Awel y Môr Offshore Wind Farm

Planning Inspectorate reference:
EN010112

Summary of Written Representation
for Examination Deadline 1 by
Gwynedd Archaeological Planning Service

24th October 2022

**Volume 6, Annex 10.5: SLVIA
Visualisations - Figure 35
(ViewPoint 8 - Beaumaris - Wales
Coast Path)**

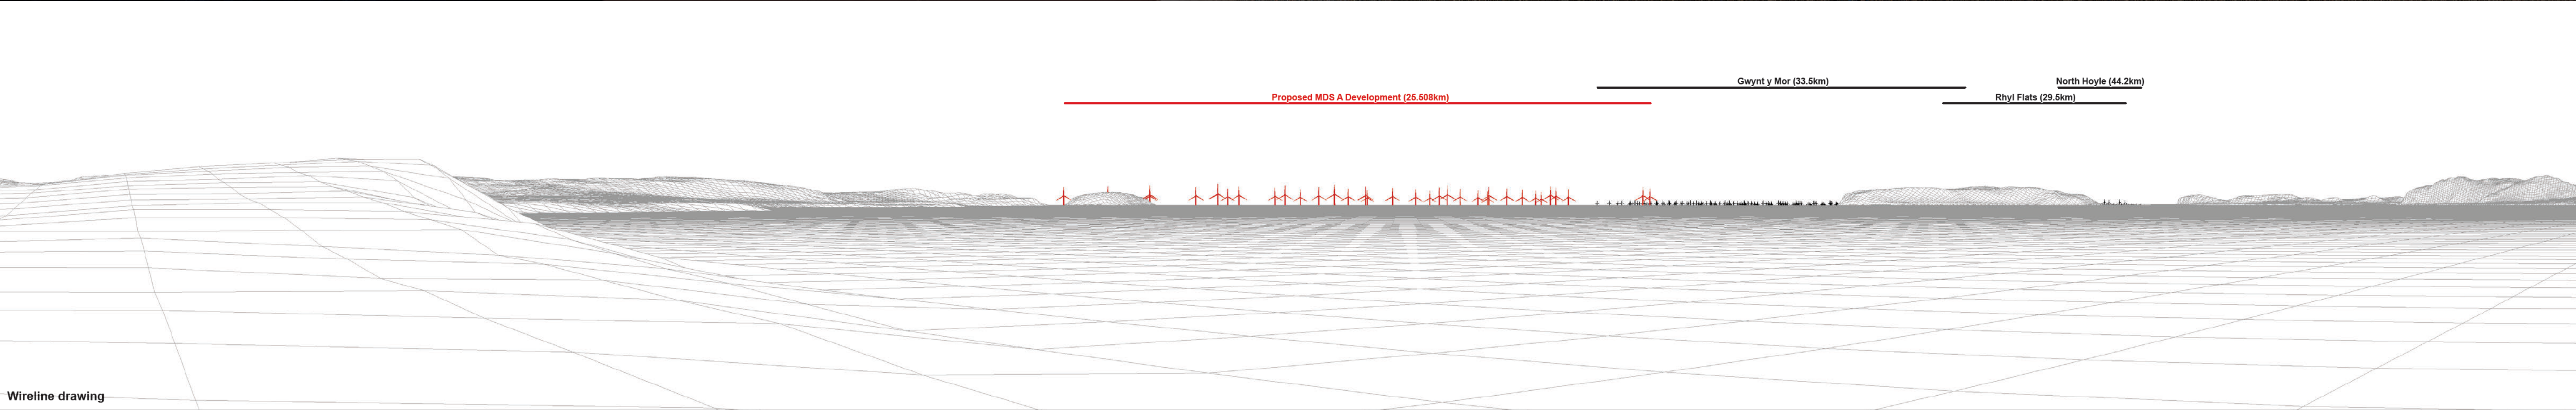
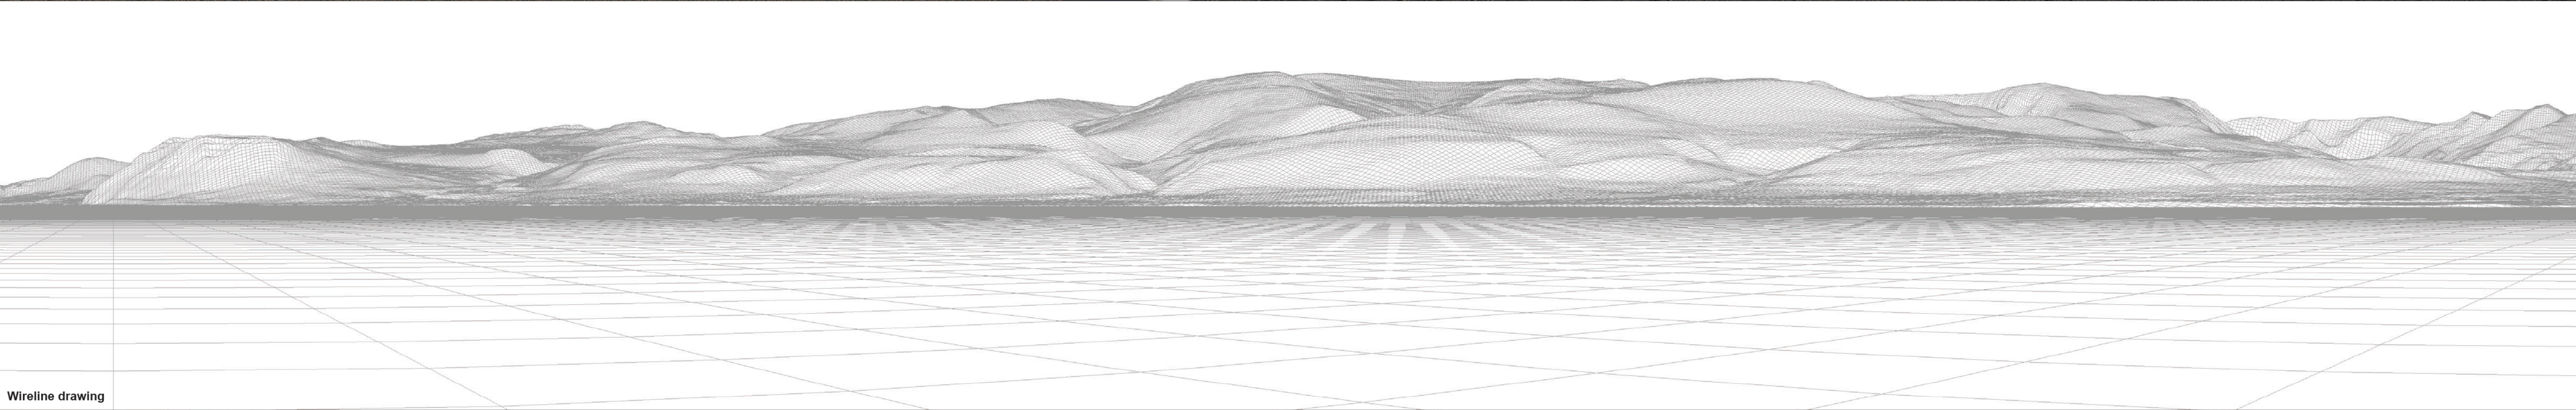
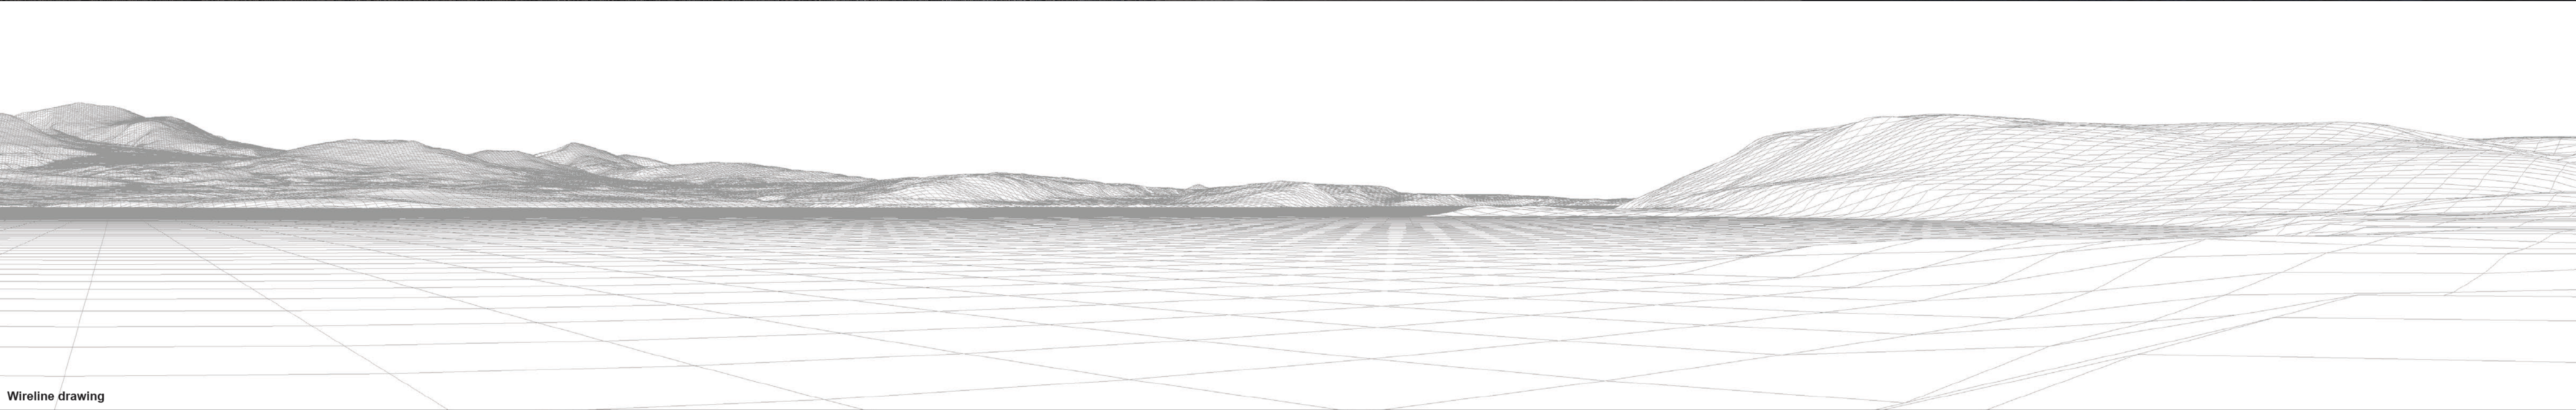
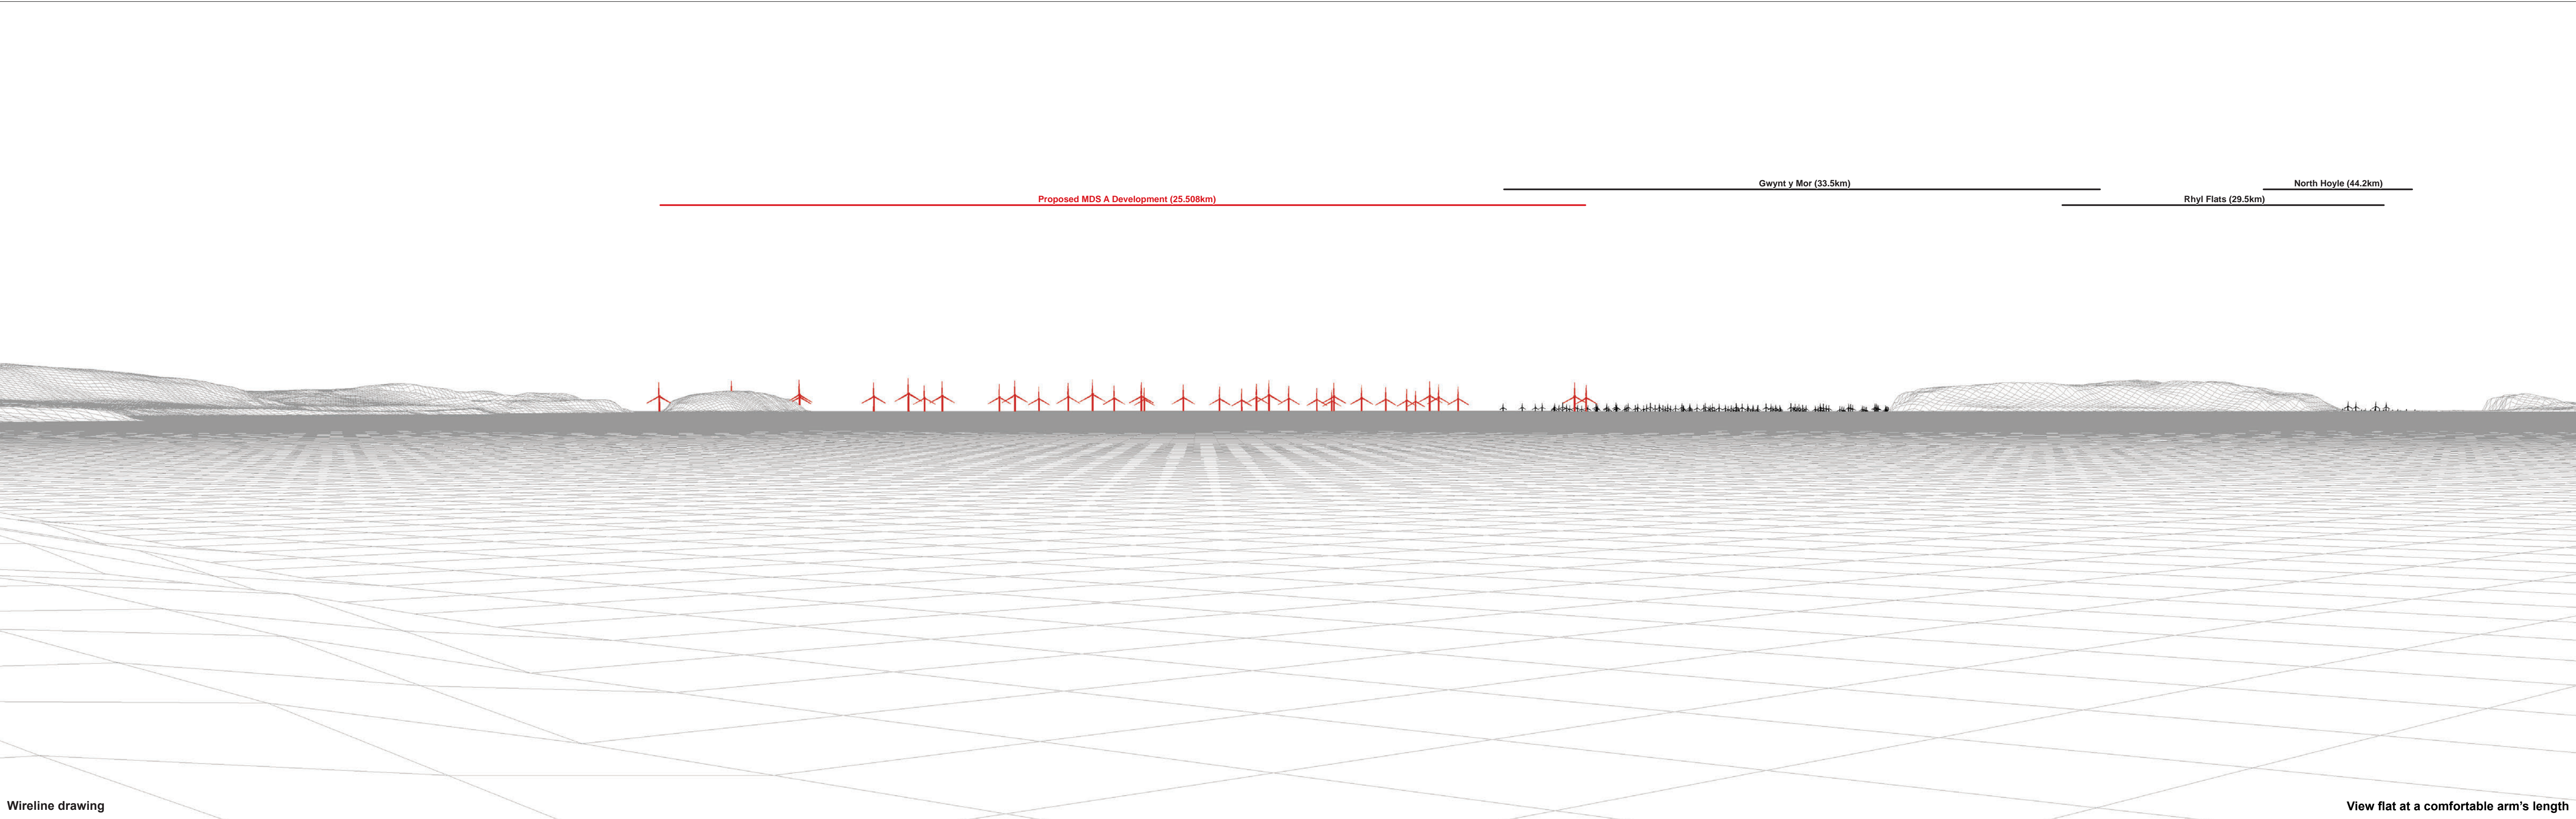
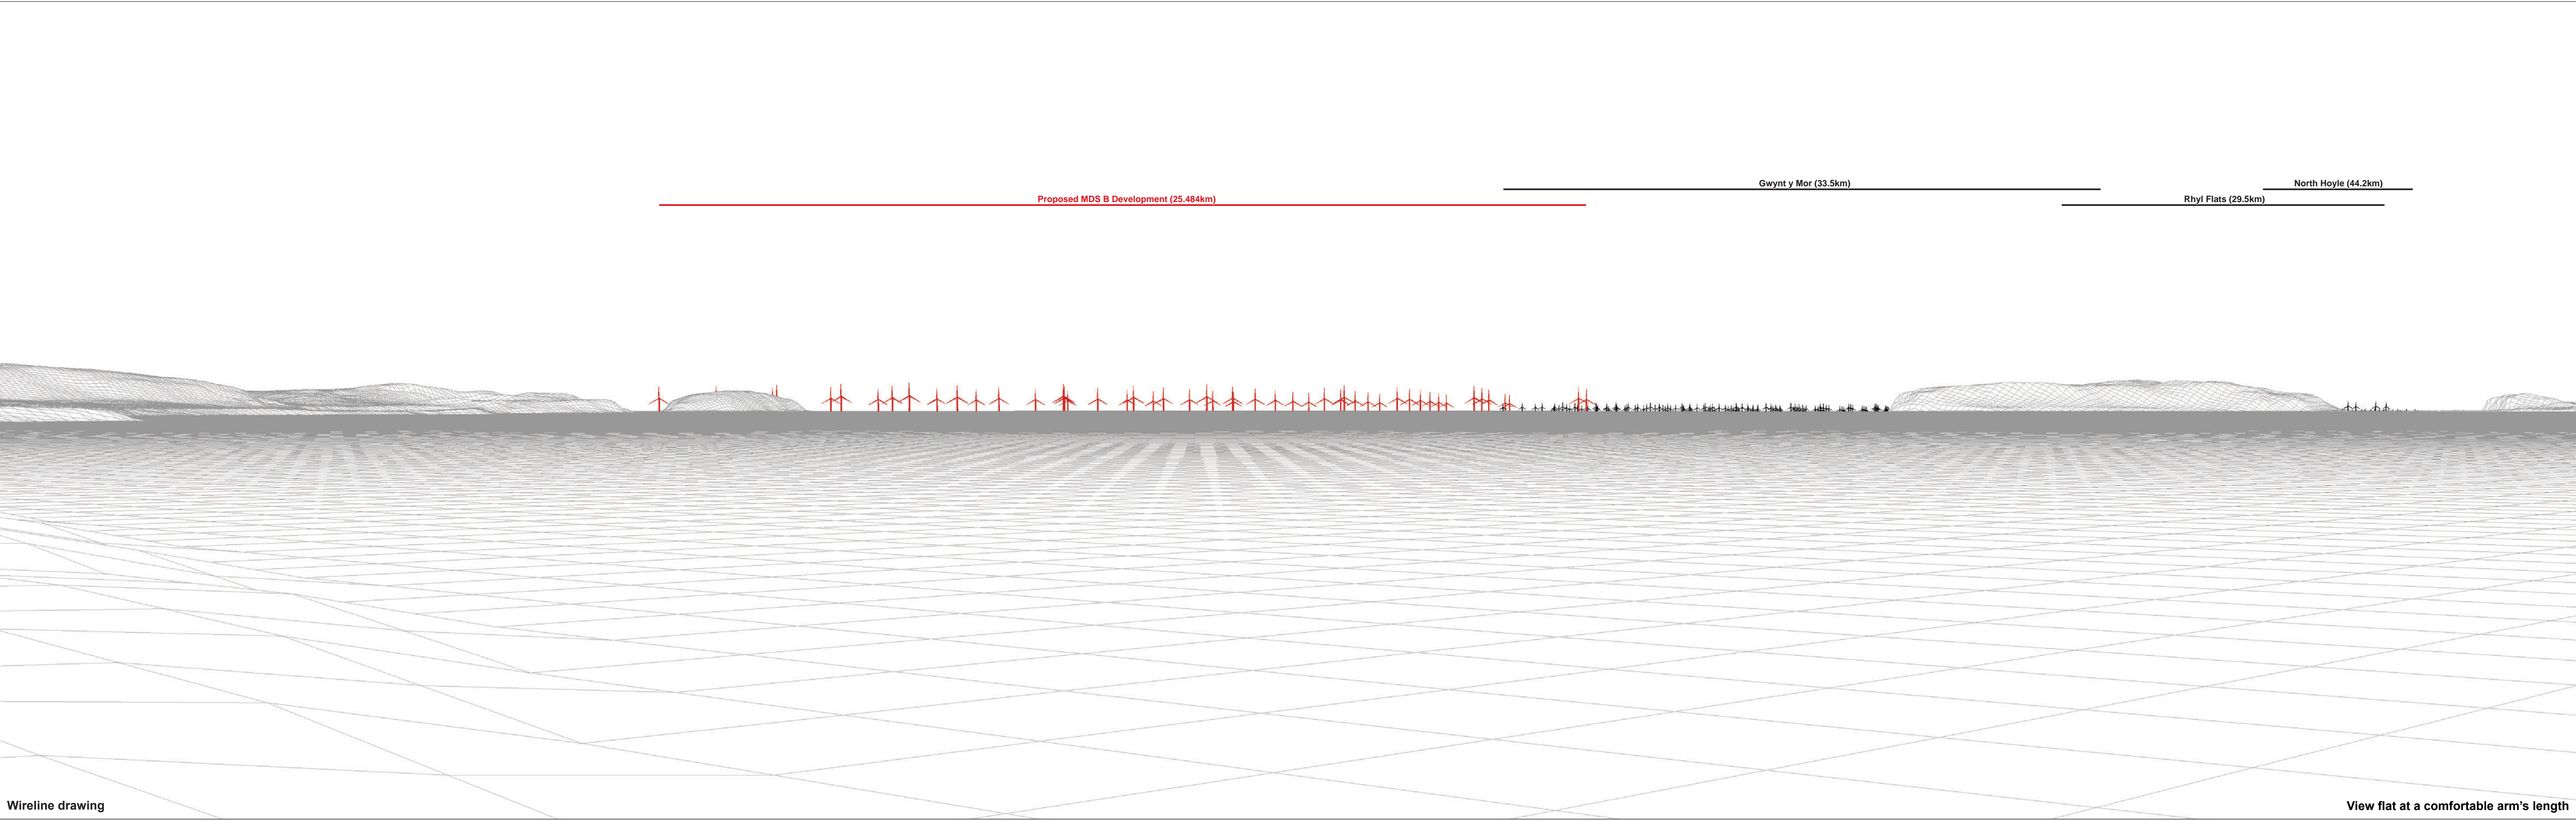
- 2.32 VP8 is a longer view from Beaumaris promenade. As described in the SLVIA, the Awel y Môr turbines are 'prominent elements on the horizon' in this view, flanking Puffin Island in such a way as to link it to mainland Anglesey and extending towards Great Orme, almost forming a visual connection. The scale of this change, from the existing vista across largely open water to the horizon, is greater than that at VP7 with a correspondingly greater effect on the value of the monument's setting.

- 2.33 In this view, we would agree with the SLVIA that the reduction in array area has not been sufficient to alter the significance of the impact. The Awel y Môr turbines would be a large, unsympathetic intrusion that dominates the skyline and substantially reduces the perception of isolation of Puffin Island, a key attribute of the setting of the monastic settlement that is important for its understanding and appreciation. As such, this would significantly reduce the contribution of setting to the significance of the monument, which would be reduced as a result. It is considered that this would constitute a high adverse impact, of moderate impact on the significance of the monument, and thus significant in EIA terms.

turbines clustered around the island in VP8 (Volume 6, Annex 10.5, Fig.35) could reduce the impact to a non-significant level.
